REQUEST TO REINSTATE AN INTERIOR LOT LINE

13980 BLACK FOREST ROAD
 LOT 7, BLOCK 1, APACHE WOODS SUBDIVISION
 EL PASO COUNTY, COLORADO

PCD FILE NO. BOA 88

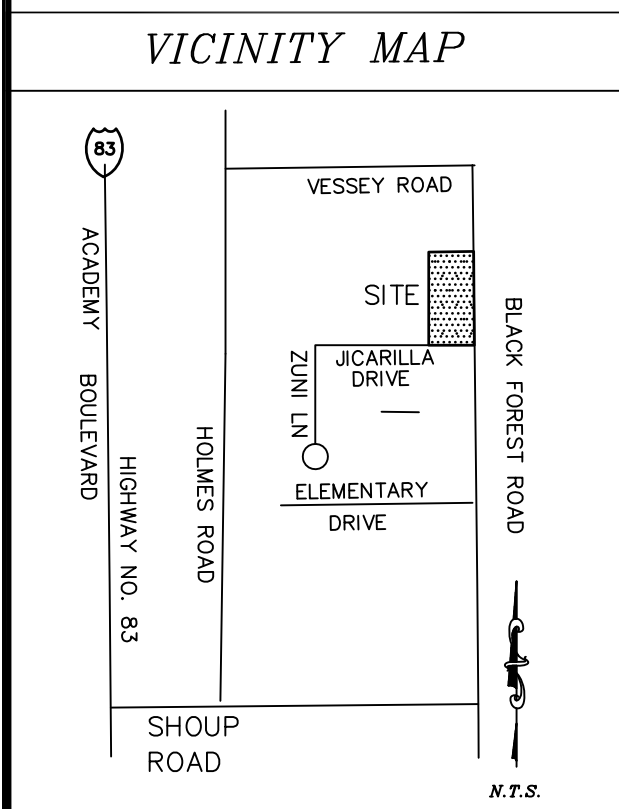
BOA188, please revise

This right of way will be dedicated at the time of final plat approval. Revise this wording.

*Note: The final plat will also need to reflect any right-of-way preservation based on the 2060 MTCP classification for Black Forest Road.

*Note - On the minor subdivision submittal, do not show the potential acreage for the adjacent properties.
